From: Dunderdale, Chris <Chris.Dunderdale@lancashire.gov.uk>
Sent: 07 September 2016 18:10
To: planning
Cc: Stephen Kilmartin
Subject: RE: Consultation on Planning Application 3/2016/0764 Primrose Works Primrose Road Clitheroe Lancashire BB7 1BS

Subject: Consultation on Planning Application 3/2016/0764 Primrose Works Primrose Road Clitheroe Lancashire BB7 1BS

The application is for: Demolition of existing workshop buildings (other than the main 3 storey element), conversion of the main 3 storey element to provide 14 residential apartments the erection of 4 residential apartments, erection of cycle/refuse store, laying out of parking and circulation areas, and associated landscaping resubmission of 3/2015/0266.

Existing Site Layout

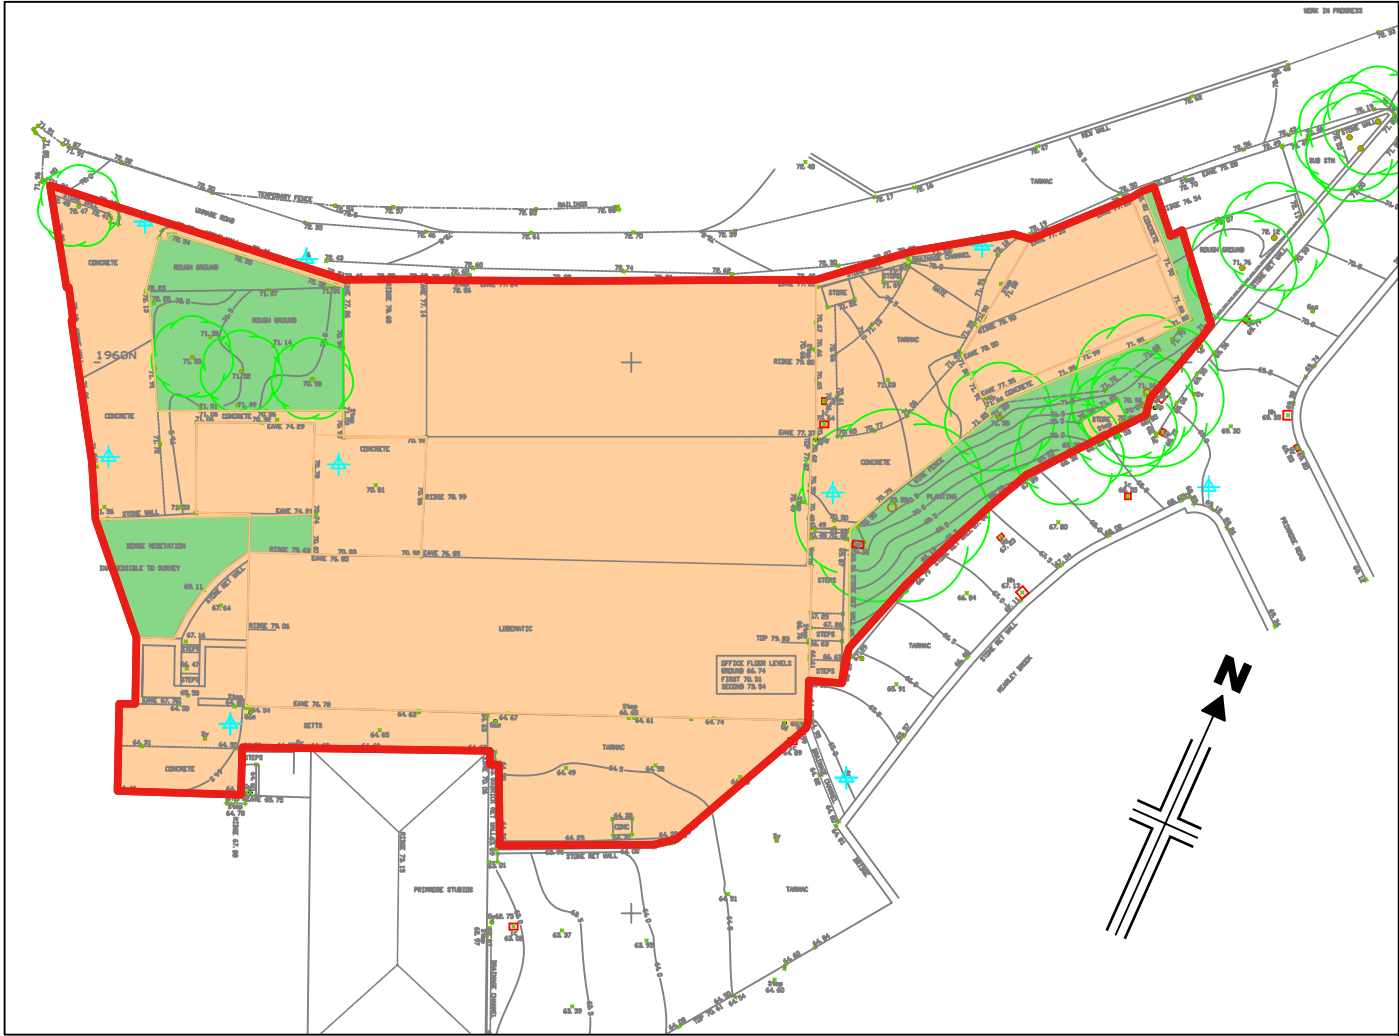
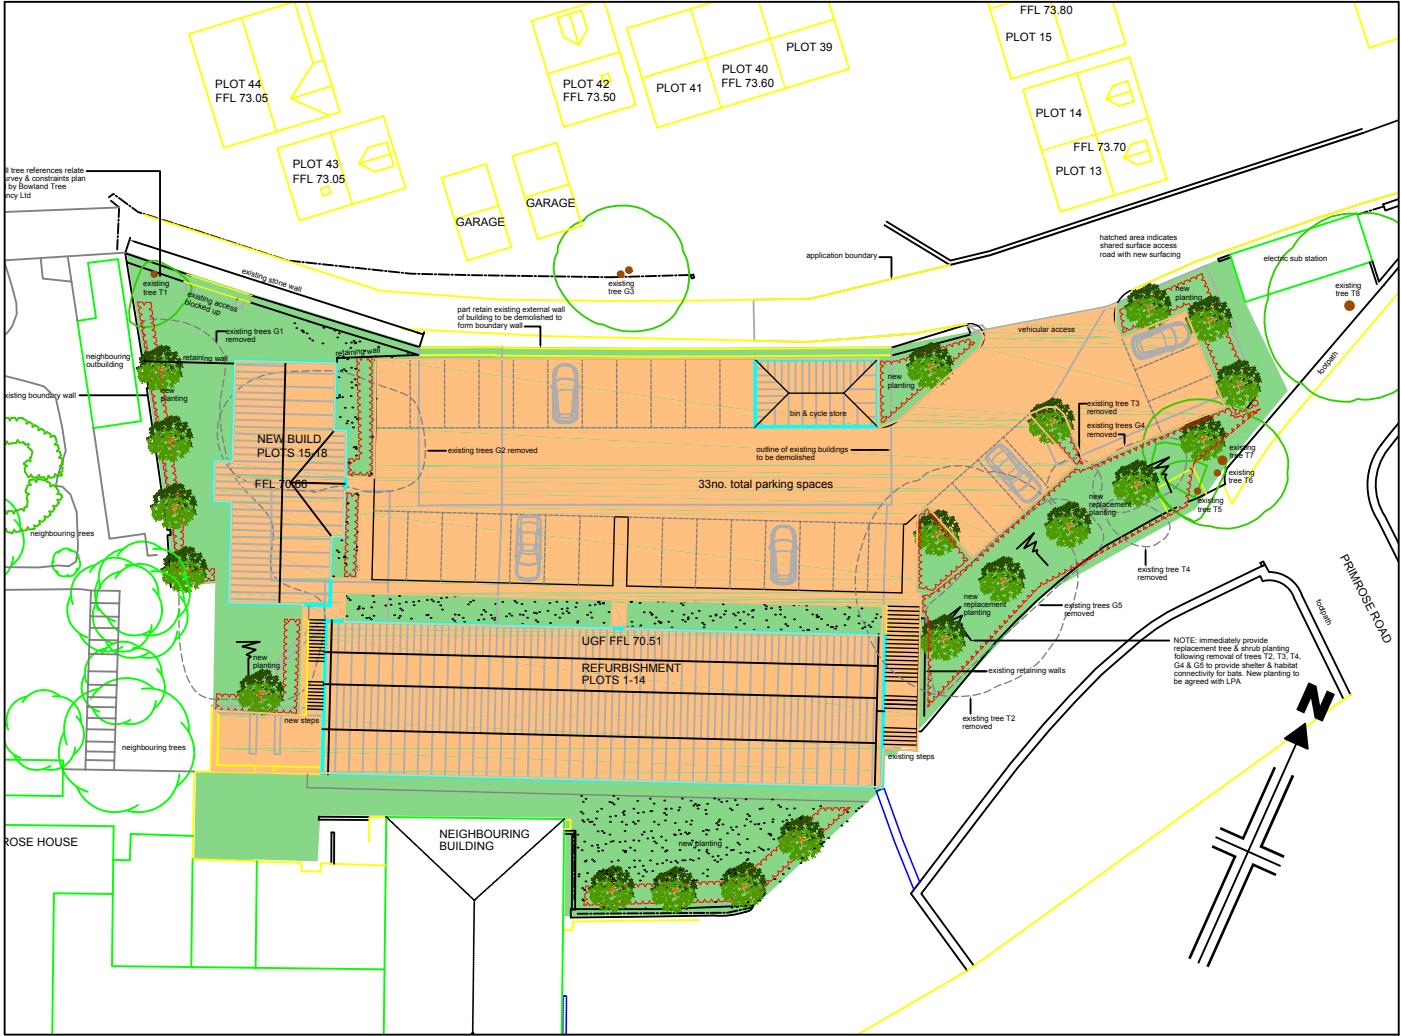
According to the application form and drainage statement the applicant intends to discharge surface water via a mains sewer. As you know, the Planning Practice Guidance establishes a hierarchy for surface water disposal which requires applicants to consider other preferable runoff destinations first, namely infiltration to ground or to a surface water body. The applicant has considered this within their drainage statement and has argued that infiltration is unlikely to be viable and that there are no watercourses within the applicants land ownership.

In principle, I would be happy to accept the applicants justification regarding infiltration (subject to a condition requiring the applicant to carry out infiltration testing at a later stage), but I do feel as though the applicant could further explore the possibility of discharging to a watercourse as there is a watercourse less than 10m from the site. I would appreciate it therefore if you could ask the applicant to provide further clarity on this. If not, then we will consider whether an objection is required.
